From: Sue Howell
Sent: 21 September 2017 14:52
To: Planning.Responses
Cc: Michael Eastham; Simon Davis
Subject: RE: Planning Consultation on: BN/28/17/RES

Comments from Greenspace

APPLICATION BN/28/17/RES

Description of Works: Approval of reserved matters following outline consent BN/32/15/OUT relating to appearance, landscaping, layout & scale for erection of 38 No. dwellings including open space, landscaping & new access

scheme: The Lillies, Yapton Rd
Barnham
client: Matthew Homes
drawing: Landscape Proposals
date: April 2017
scale: 1:200@A1
drawing no: MAT21212 11A sheet 1
drawn: AE checked: DKM

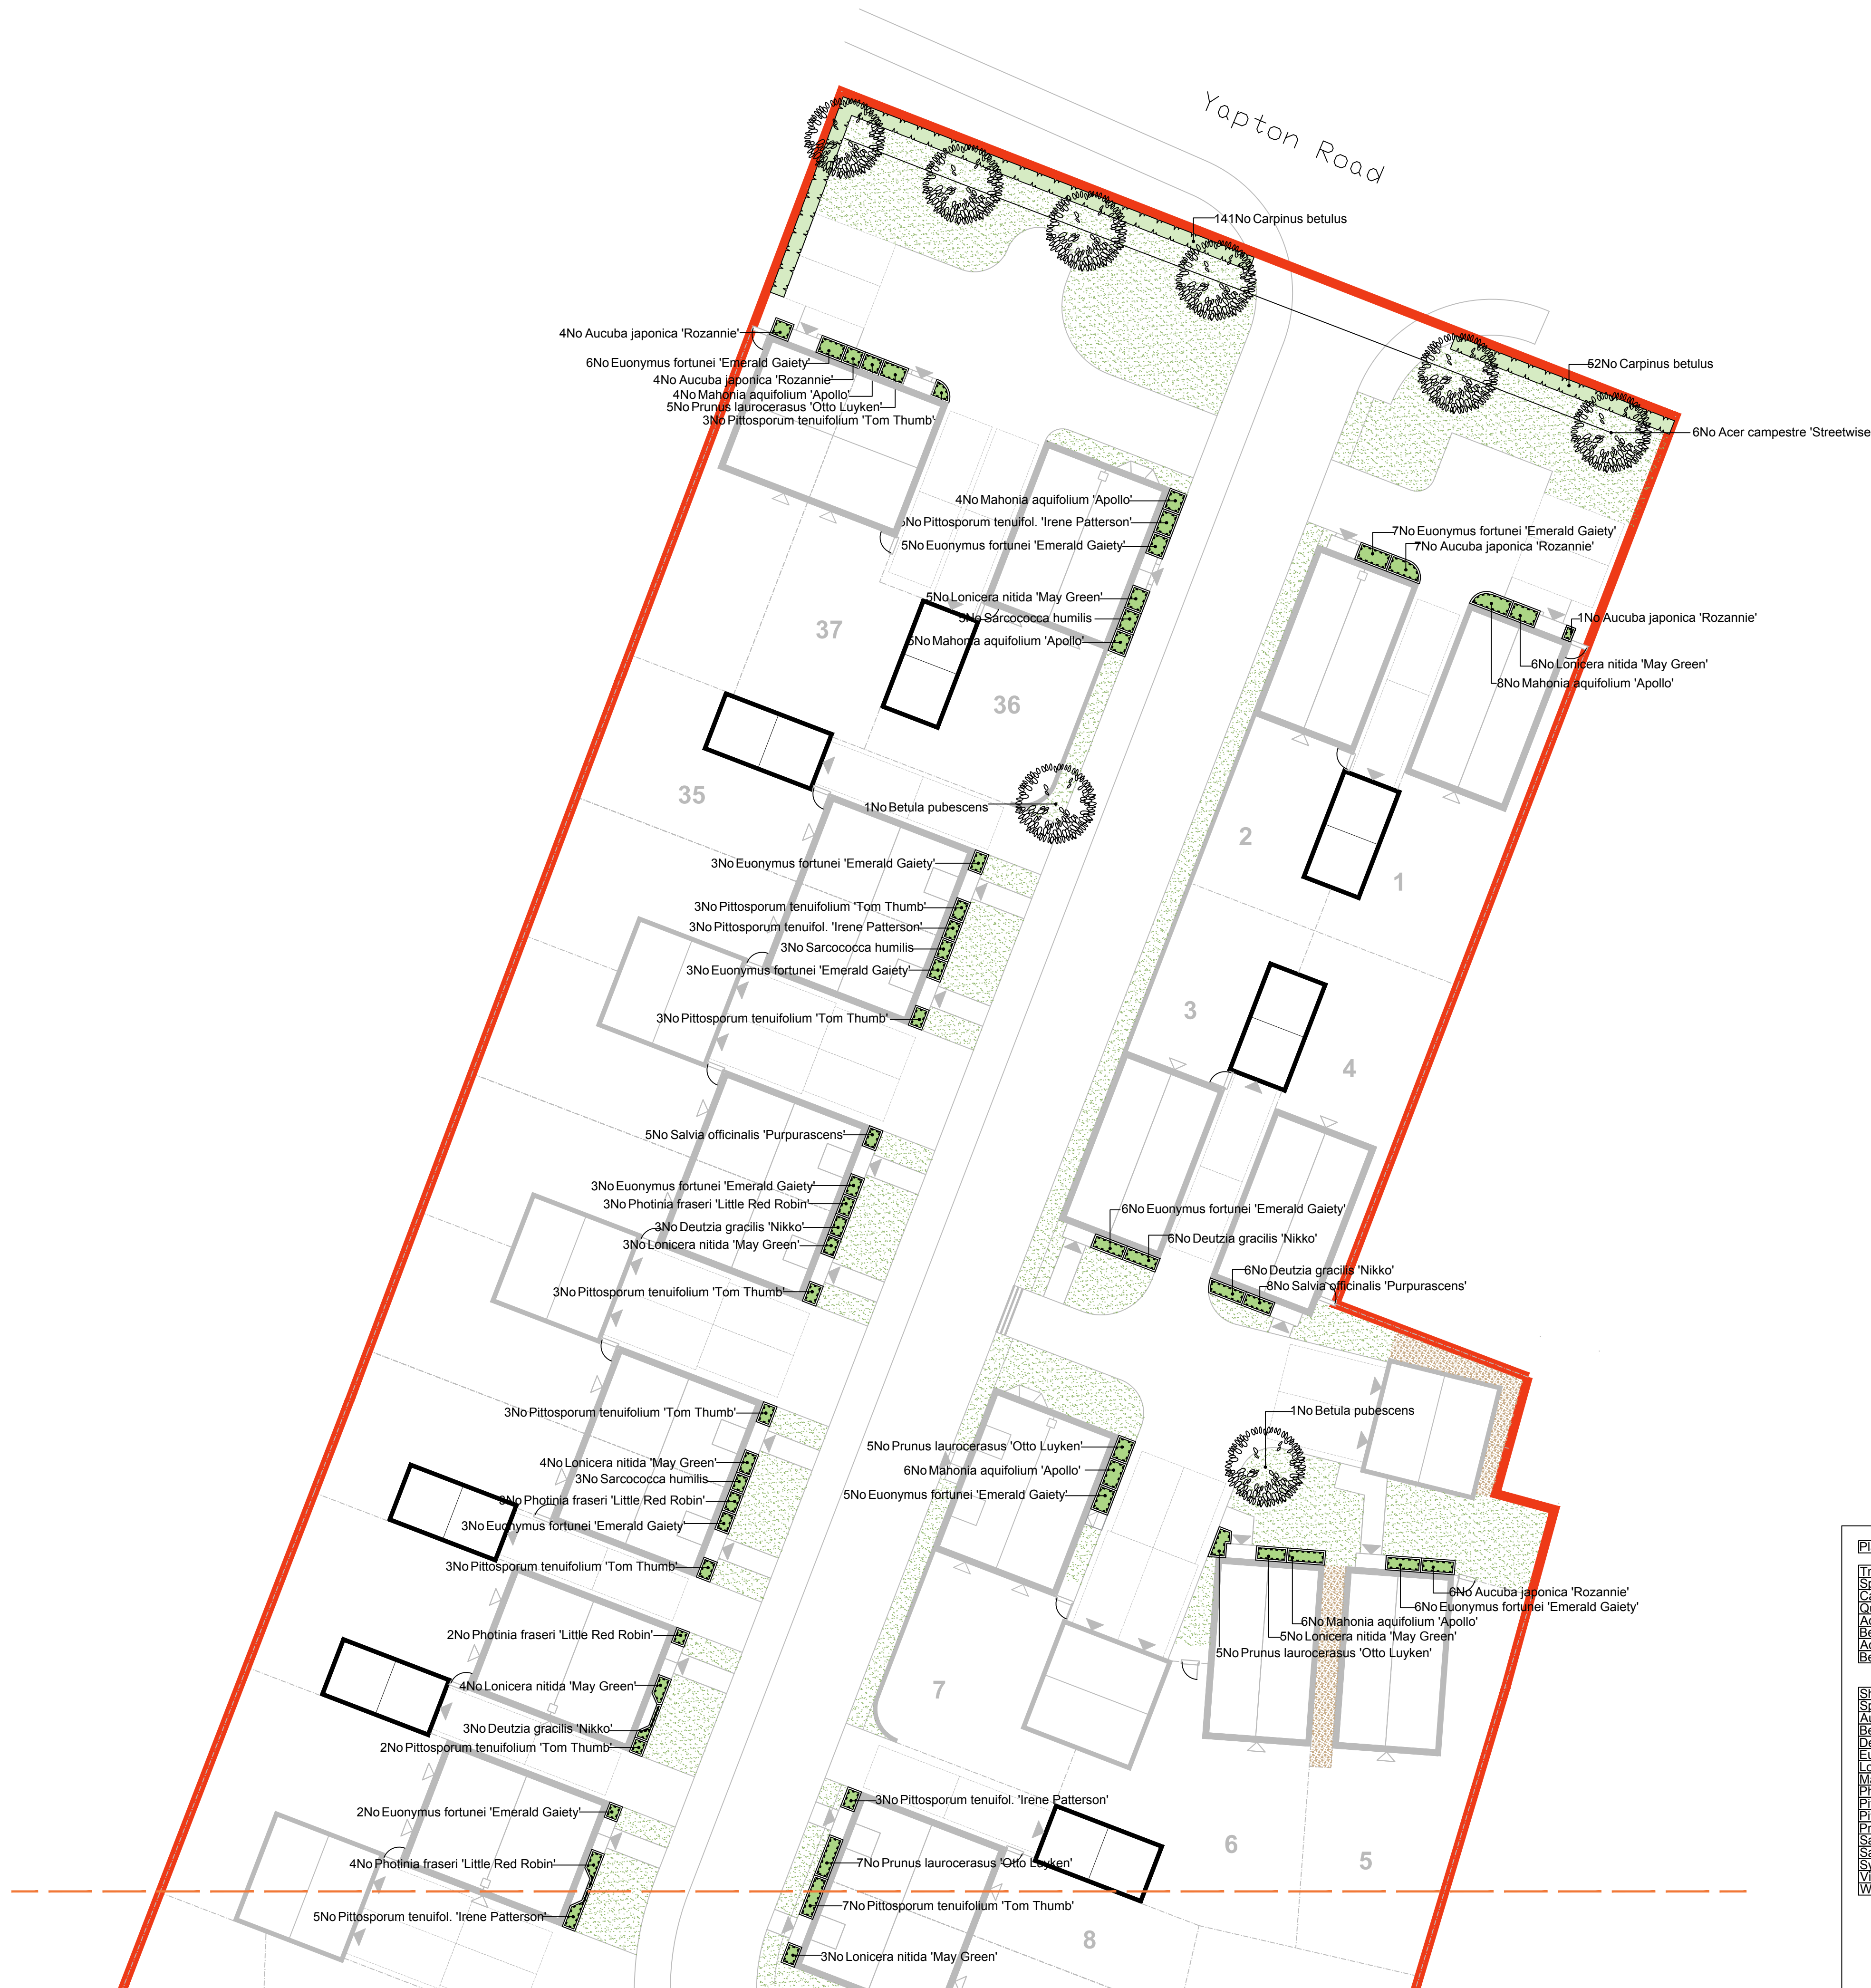
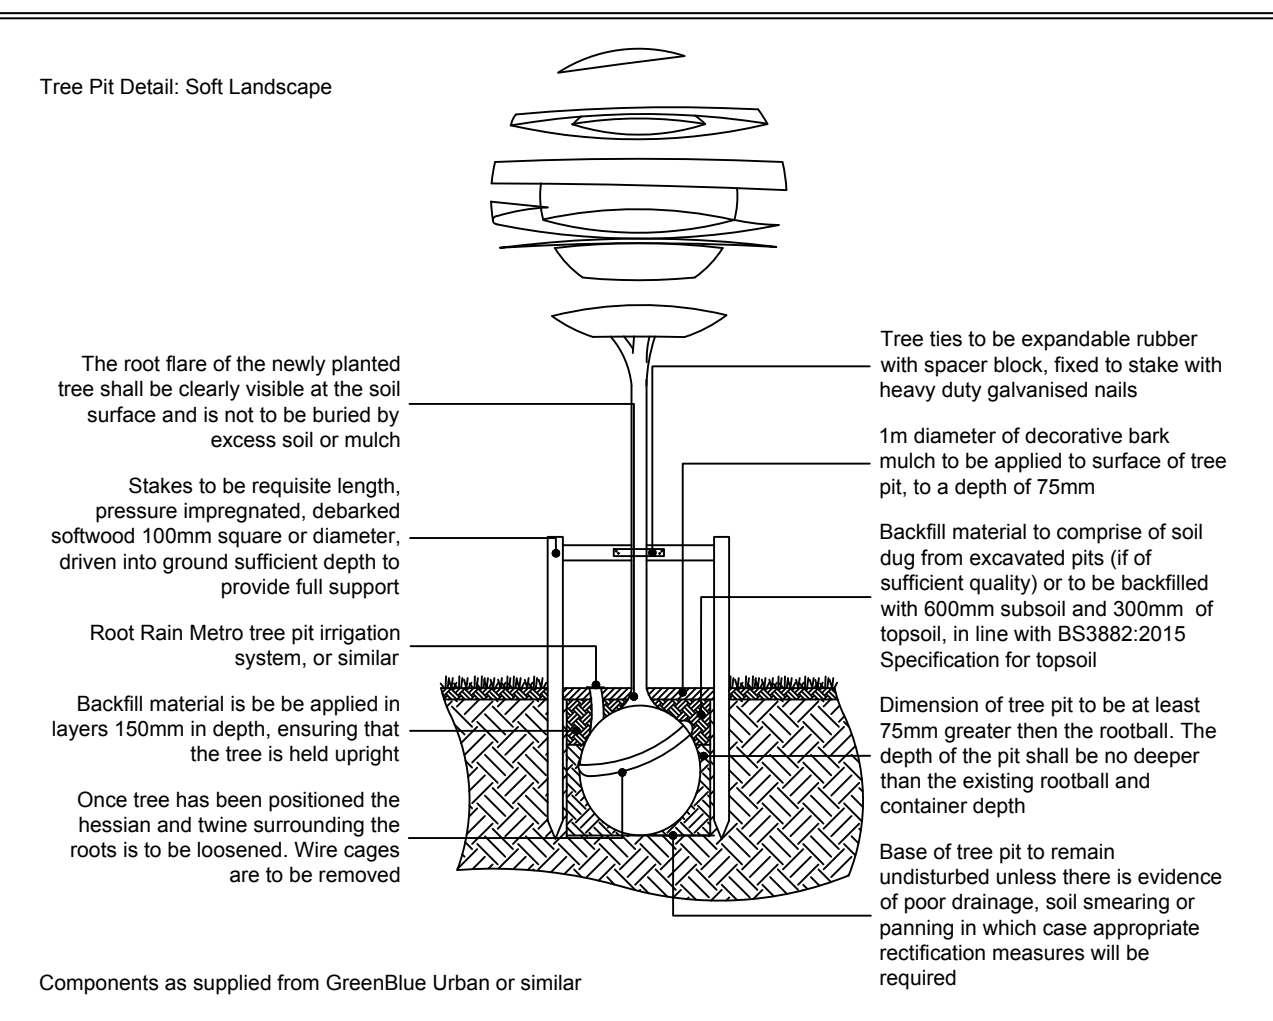
The revised drawings MAT21212 11A sheets 1 & 2 differ greatly from those submitted and approved within the outline stage. The outline plans indicated that the Public Open Space to be centrally positioned with connection to the west of the site; drawings stating 'Pedestrian footpath & Open Space connecting with neighbouring land. The layout now submitted has the area of open space now in the south west corner of the site behind the flats 19-24 which is tucked away does not benefit the wider development and with no shown connection to the wider surround. This in addition now precludes the formation of the green corridor previously proposed.

The revised drawings show an overall reduction in the open space being provided within this development which again differs from the outline application. The area of greening along Yapton Road is also now shown as reduced in area and now forming hardstanding and turning area.

The Landscape proposals plans detailing plant mix and size again shown a significant reduction to the intended tree planting proposed in comparison with the offer detailed in the outline application.

There is no mention of play provision with the site, which a development of this site would trigger the need for. Play provision needs to be detailed and agreed, S106 monies would be sought for offsite play if provision is not included within the site.
